About the application

Application number: 2024/92651	
What is the application for?:	Hybrid planning application comprising full application for erection of industri
Address of the site or building:	land at, Blackmoorfoot Road, Crosland Hill, Huddersfield, HD4 5NU
Postcode:	LS18 4RJ

TYPICAL BIN STORE DETAILS

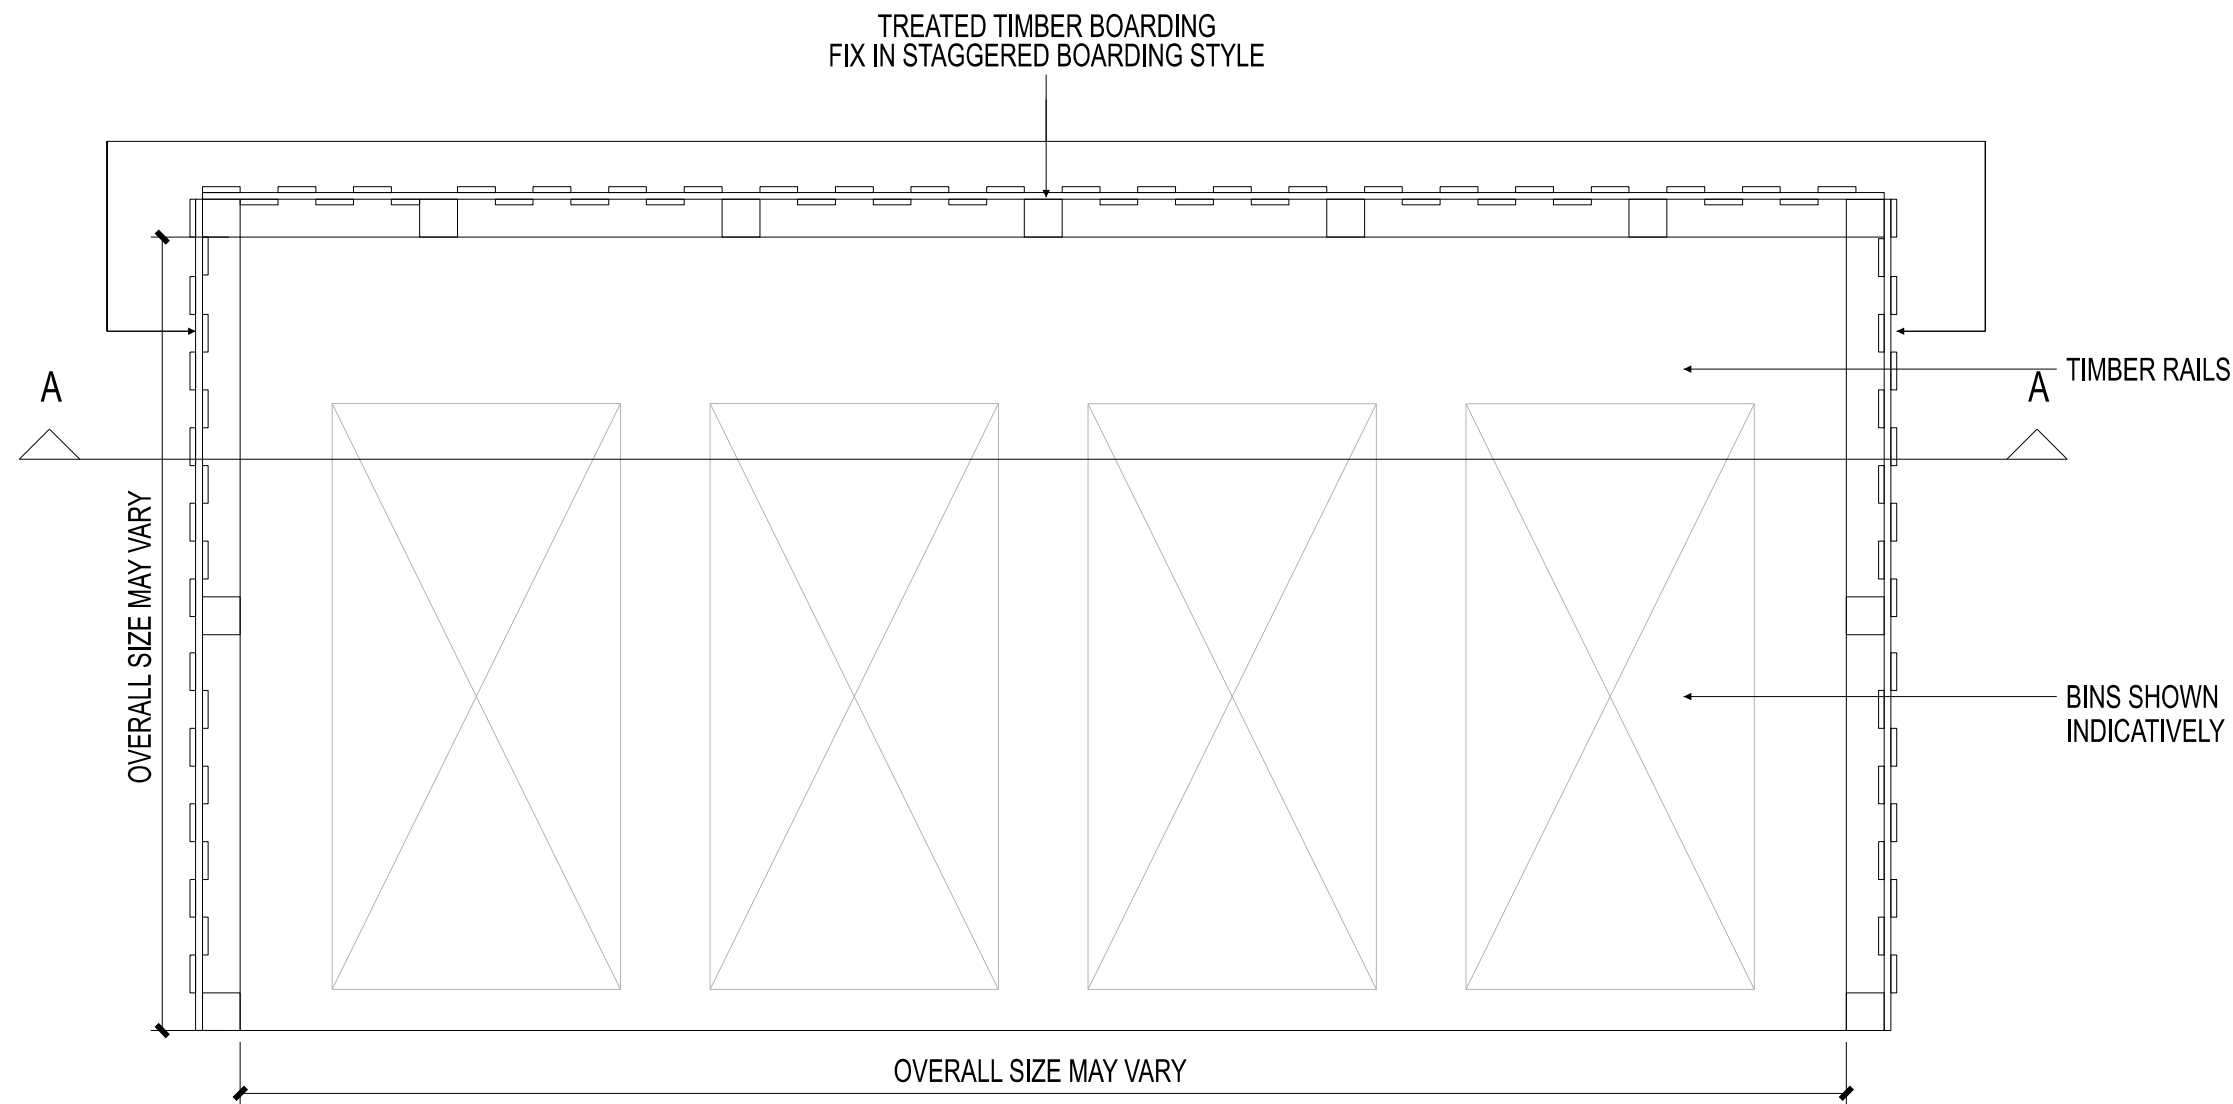
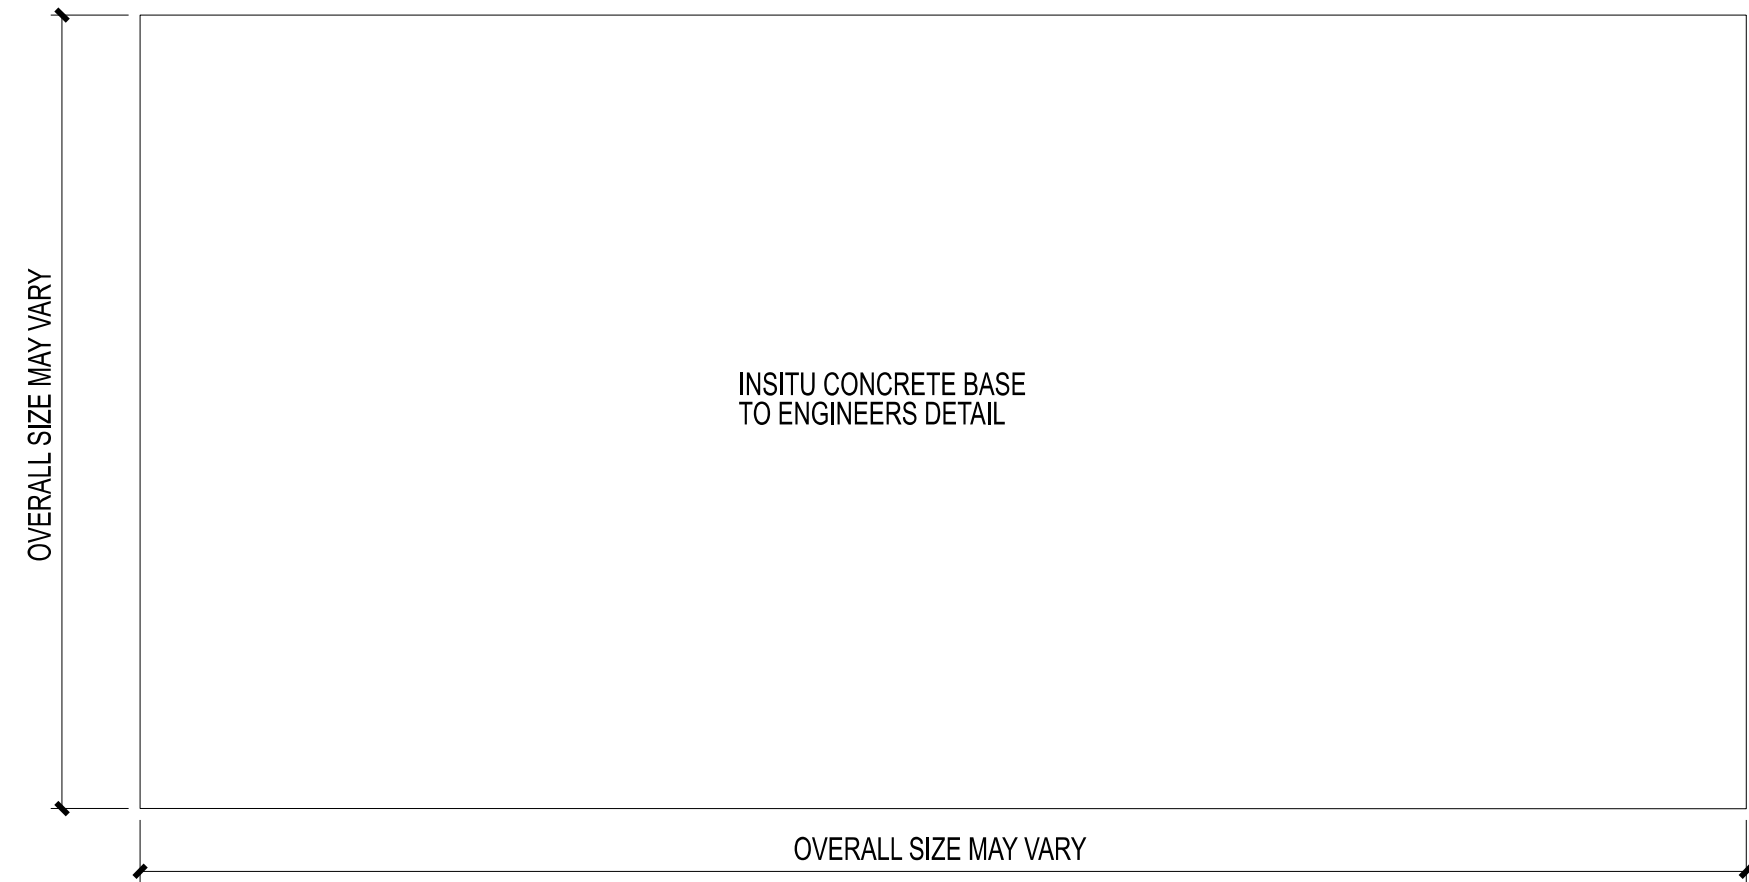
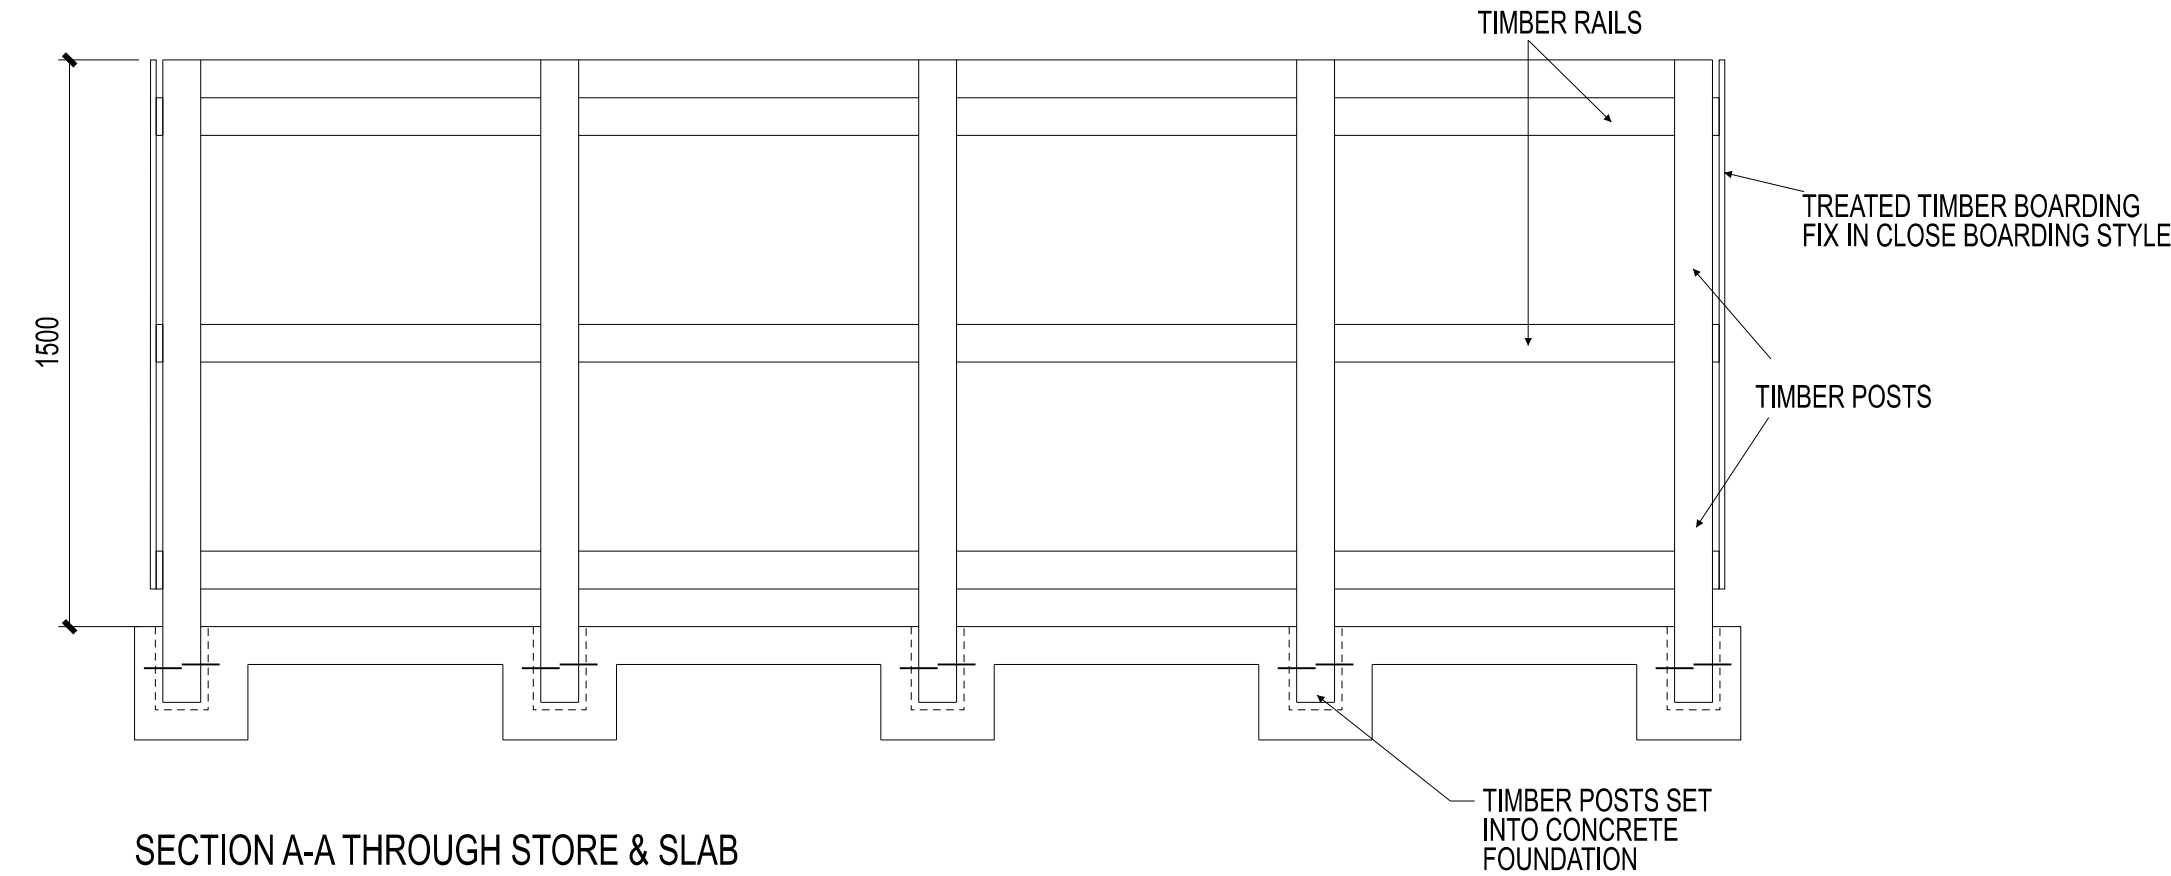
Type of comment: A general comment	
Do you wish your comments to be published on the website anonymously?	<input type="checkbox"/> Yes
<p>Reviewing the proposed plans for the development, it's noted that the location of the bins are towards the adjacent housing estate. It would be preferred if the bins could be relocated away from the existing housing estate.</p> <p>These could provide odours, attract vermin and other such unwanted aspects for the bins.</p> <p>The units could be used by various different companies offering a wide variety of uses and location of the bins could cause offence during the various tenants/owners of the units.</p>
